Springwell Solar Farm

Volume 8
A15 Road Safety Audit
& Designer Response

Springwell Solar Farms – A15 Access Works

Stage 1 Road Safety Audit

| DRAWING NO:<br>SPR1-05-DR-0208<br>SHEET 1 OF 1 | REVISION:<br>P01 |

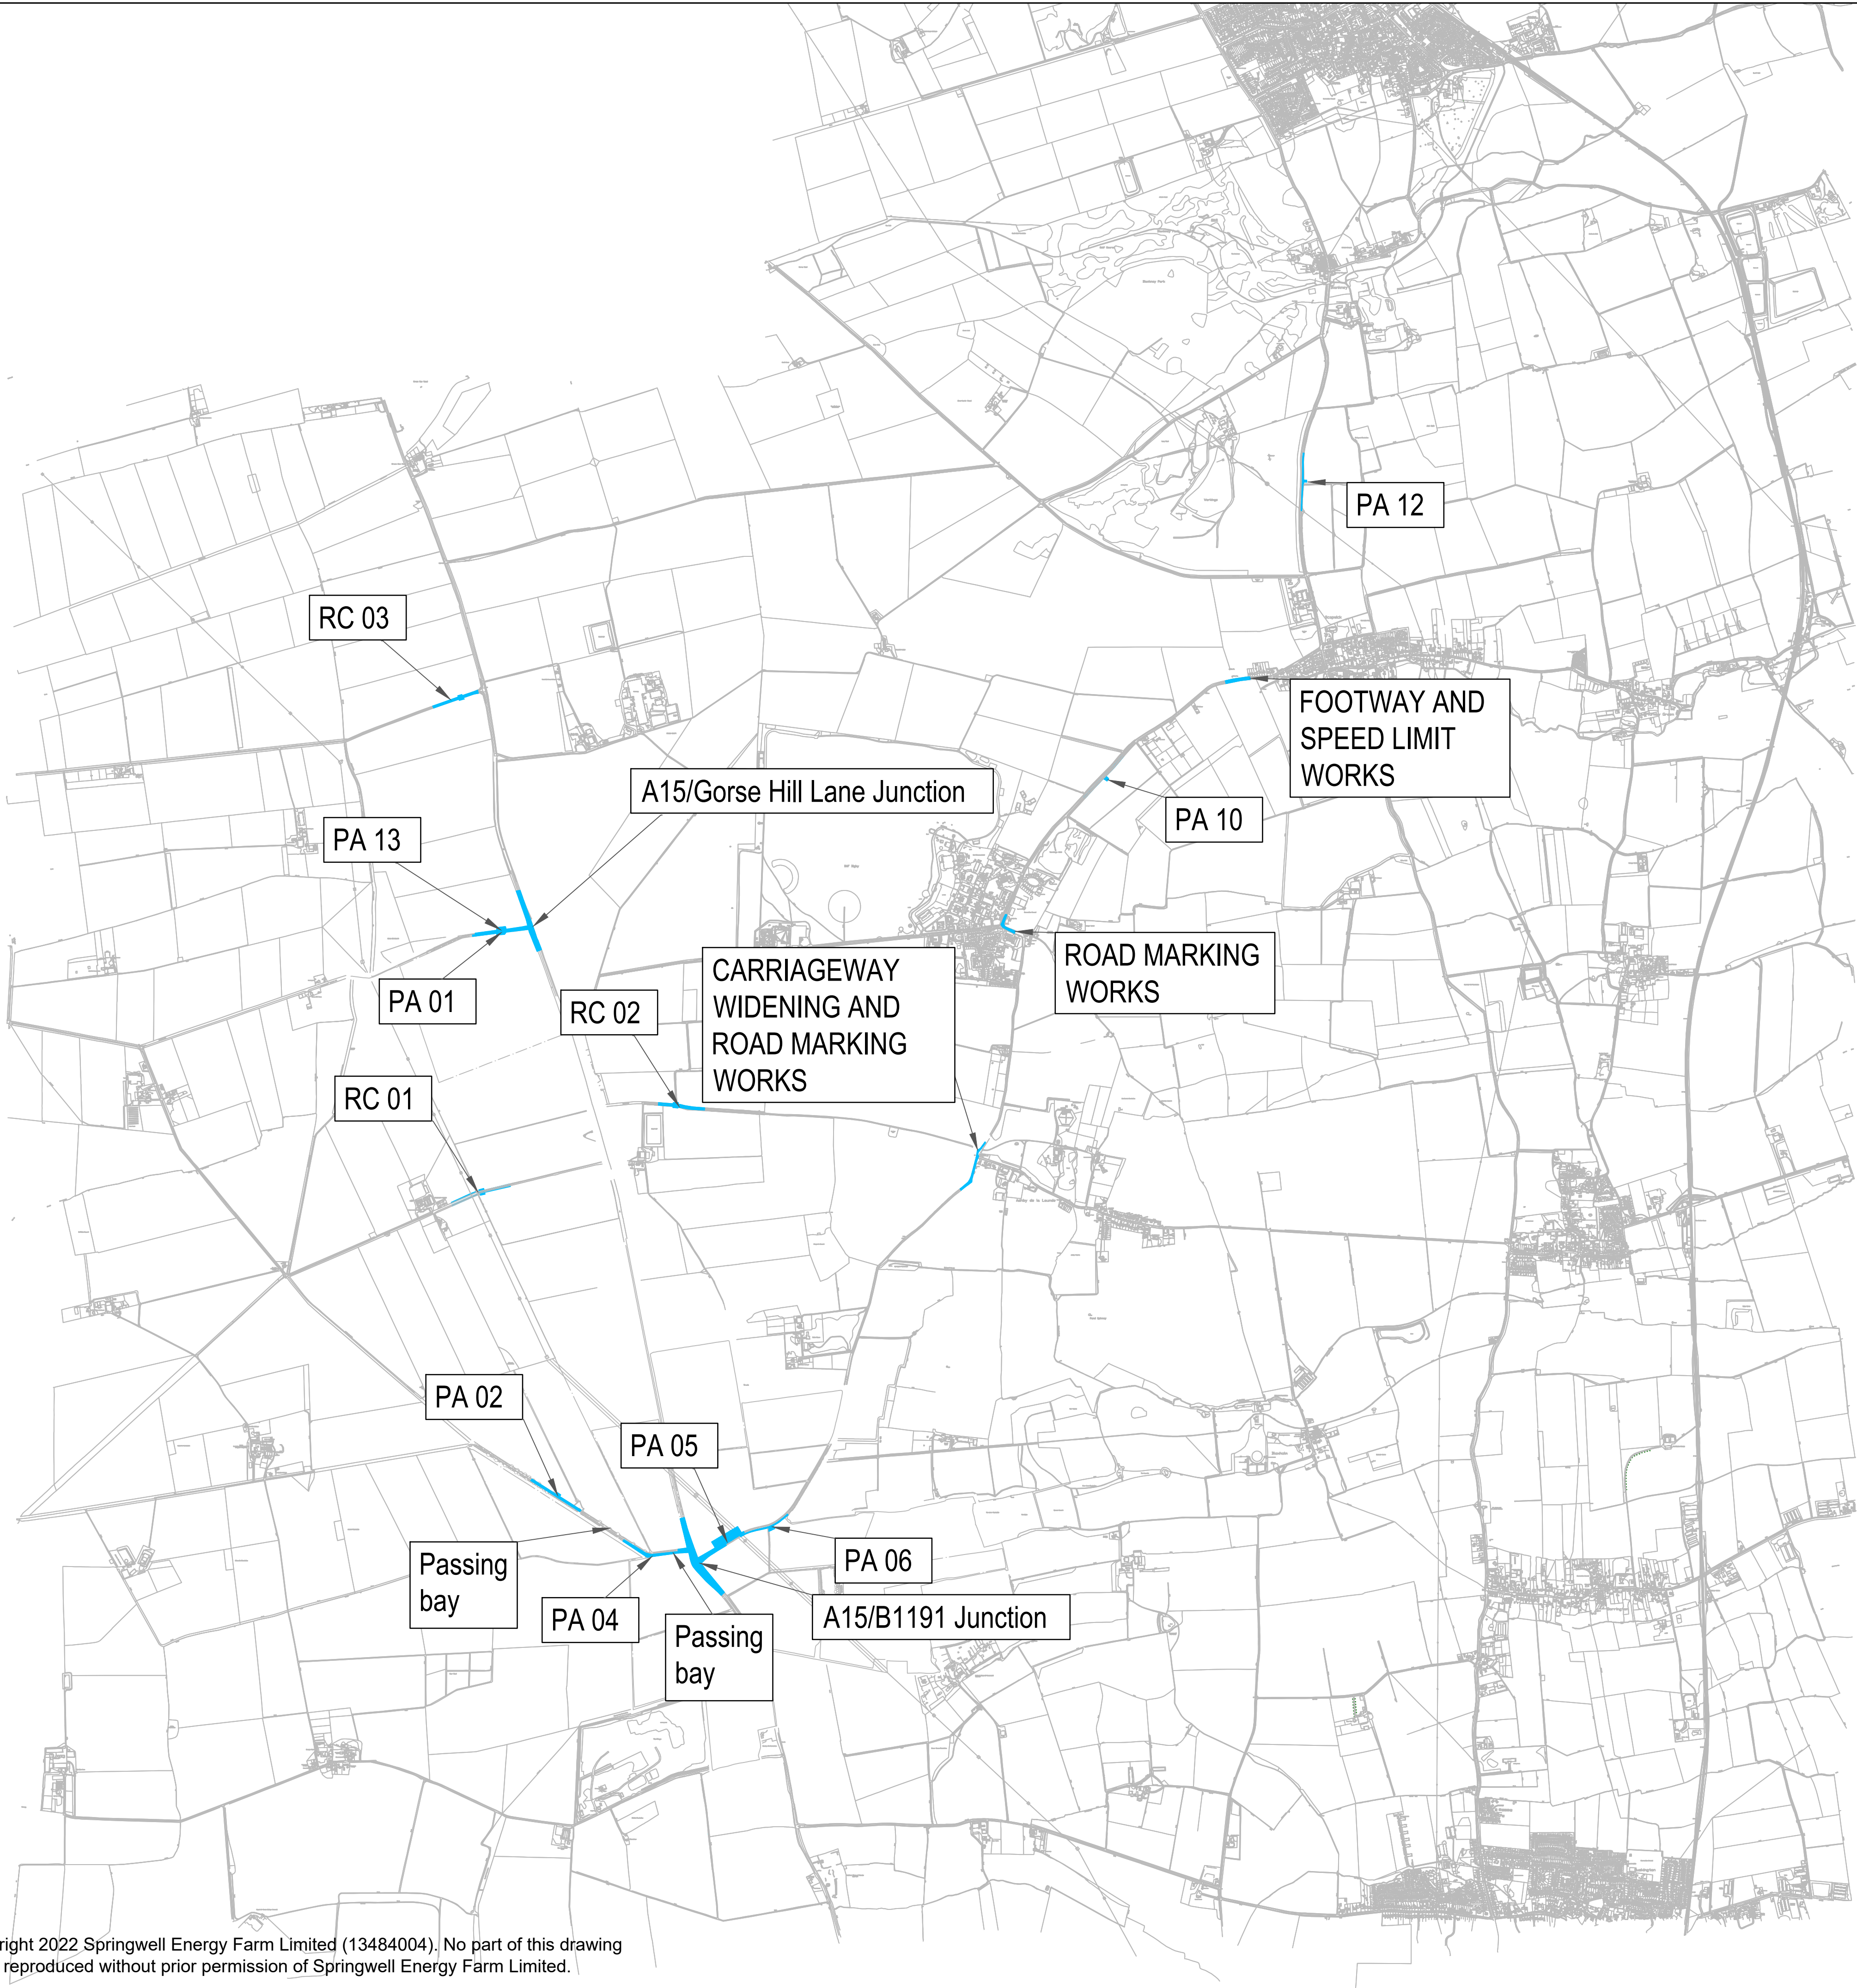
Location: Gorse Hill Lane, tie-in to existing track.

Summary: Abrupt tie-in detail directs westbound traffic into verge, landscaping and trees, with potential for collision with landscaping/ trees and loss of control collisions.

Description: The proposed arrangement ties-in abruptly with the existing carriageway/ track width, with no taper or road markings to direct westbound traffic back into the existing track. Subsequently, westbound traffic is directed into the existing verge area, landscaping and trees with potential for collisions with these features and loss of control collisions, particularly during the hours of darkness when visibility is reduced.

Taper the proposed carriageway into the existing carriageway extents, providing a centre line where width allows.

Location: Gorse Hill Lane, existing interface.

Summary: Existing carriageway surface is worn and uneven, and appears unsuitable for heavy/ abnormal vehicles or increased traffic flows, which could result in loss of control collisions or potential for vehicles to shed their loads.

Description: The proposed development is predicted to provide an additional 405 vehicles utilising Gorse Hill Lane in both directions daily. The existing road surface is significantly uneven along its extents and additional vehicles, particular heavy goods and abnormal loads, using the route will result in further degradation to the carriageway surface. The unsuitable carriageway surface could lead to loss of control collisions, in addition to potential for vehicles to shed their loads.

Undertake assessment of existing carriageway conditions to determine suitability and resurface where applicable.

Location: Gorse Hill Lane back of verges.

Summary: Levels difference between proposed carriageway extents and adjacent field could lead to carriageway failing to support the weight of larger vehicles, which could lead to loss of control collisions or vehicles shedding their loads.

Description: Gorse Hill lane is upgraded to provide one lane in each direction to accommodate the development traffic. There is an existing level difference between the carriageway and adjacent land. Large/ abnormal vehicles will add strain with potential for landslides resulting in loss of control collisions, vehicle toppling/ destabilisation and potential for vehicles to shed their loads.

Earthworks to be detailed to provide sufficient construction base for carriageway and expected vehicle loadings. Furthermore, where a levels difference is identified at the edge of the carriageway, the designer will need to undertake a Road Restraint Risk Assessment Process (RRRAP) to understand whether a VRS (vehicle restraint system) is required.

RSA Issue	RSA Recommendation	Designer Response	Overseeing Organisation Response	Agreed Action
A1.1.1	Taper the proposed carriageway into the existing carriageway extents, providing a centre line where width allows.	<p>Agreed. A suitable taper will be provided to allow the road width to return to existing width.</p> <p>The design of this feature will be undertaken at the detailed design stage, secured under the CTMP and for the approval of LCC.</p>		
A2.2.2	Undertake assessment of existing carriageway conditions to determine suitability and resurface where applicable.	<p>Noted. It is proposed that the track leading from the A15 through to the proposed site access junction and beyond to the proposed taper will be in a metalled surface to adoptable standards.</p> <p>The design of the road makeup will be undertaken at the detailed design stage, secured under the CTMP and for the approval of LCC.</p>

A2.2.1	Earthworks to be detailed to provide sufficient construction base for carriageway and expected vehicle loadings. Furthermore, where a level difference is identified at the edge of the carriageway, the designer will need to undertake a Road Restraint Risk Assessment Process (RRRAP) to understand whether a	<p>Noted. The earthworks design and an RRRAP assessment will be prepared at the detailed design stage, secured under the CTMP and for the approval of LCC.</p>
